**WELWYN HATFIELD BOROUGH COUNCIL
EXECUTIVE DIRECTOR - PLANNING, PUBLIC PROTECTION AND GOVERNANCE**

Application No: 6/2022/2080/PN8
Location: 24 Worcester Road Hatfield Hertfordshire AL10 0DX
Proposal: Prior approval for single storey rear extension 6m in depth, 2.57m in height and 2.27m to the eaves
Officer: Mrs Kerrie Charles

Recommendation: Prior Approval Required and Refused

Drawing No: 5584-P02-PR Revision:

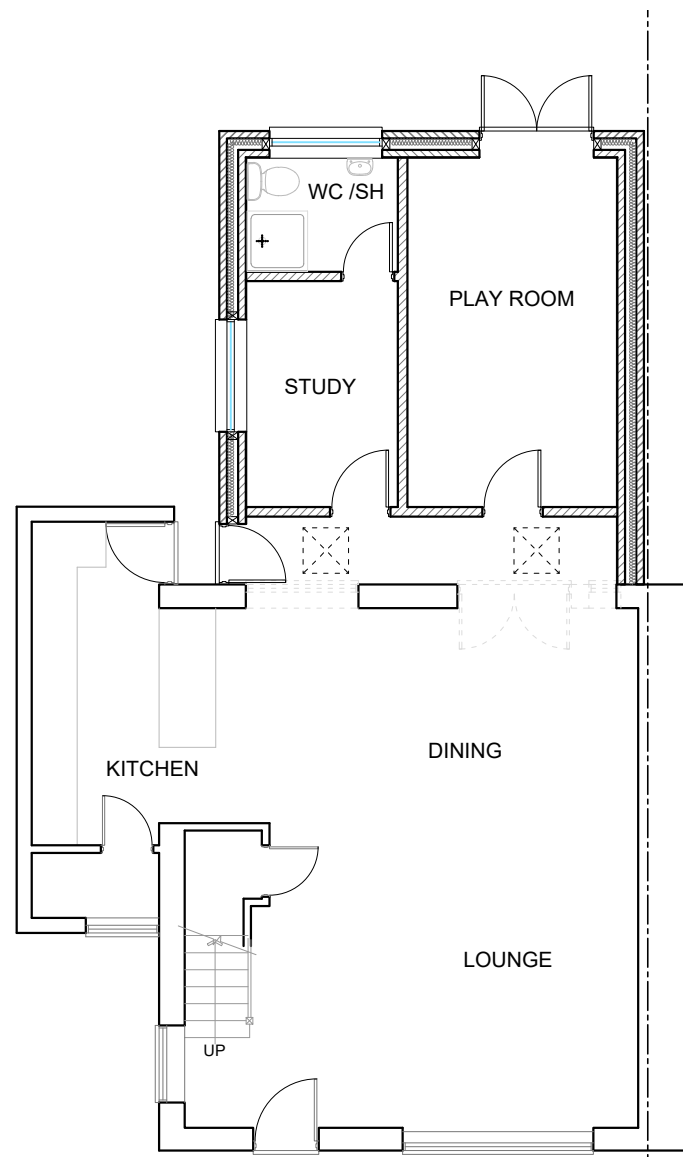
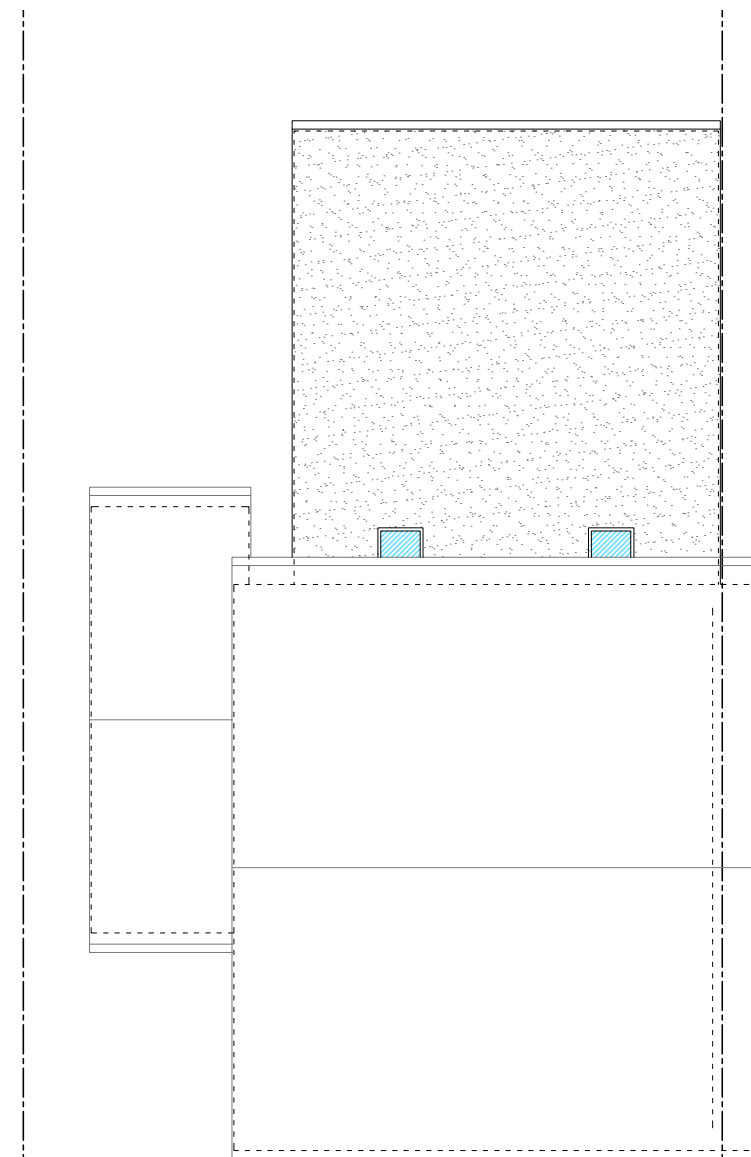
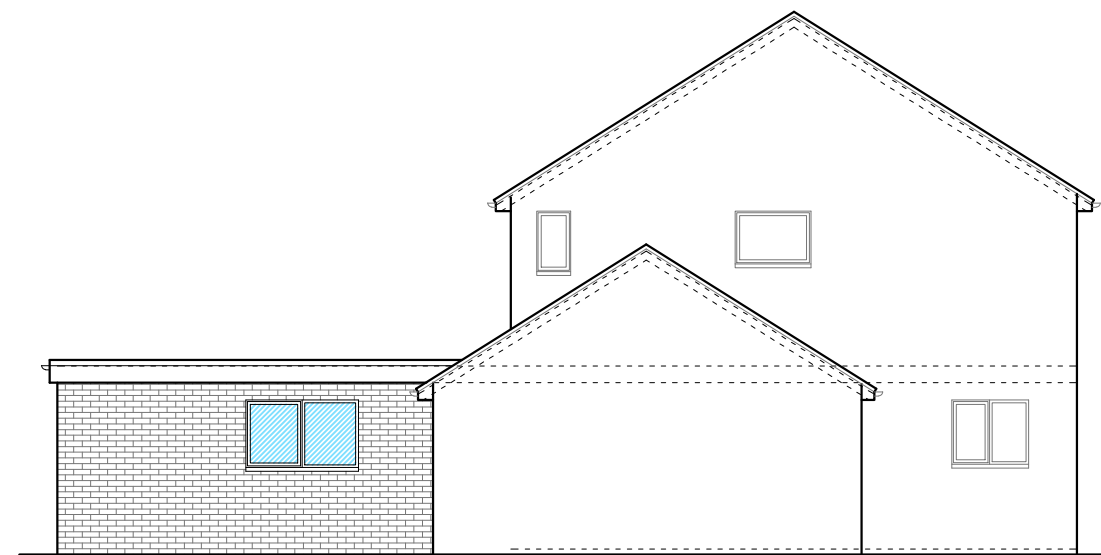
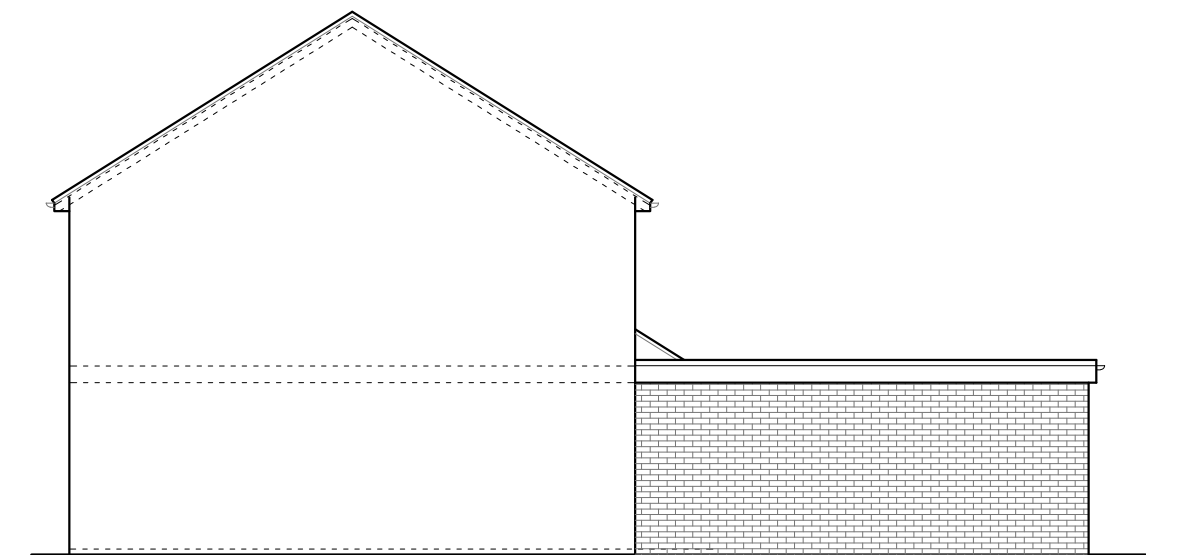
1. The proposed works are NOT permitted development by virtue of Schedule 2, Part 1, Class A of the Town and Country Planning (General Permitted Development) (England) Order 2015 as amended by virtue of the enlarged part of the dwellinghouse would extend beyond a wall forming a side elevation of the original dwellinghouse and have a width greater than half the width of the original dwellinghouse.
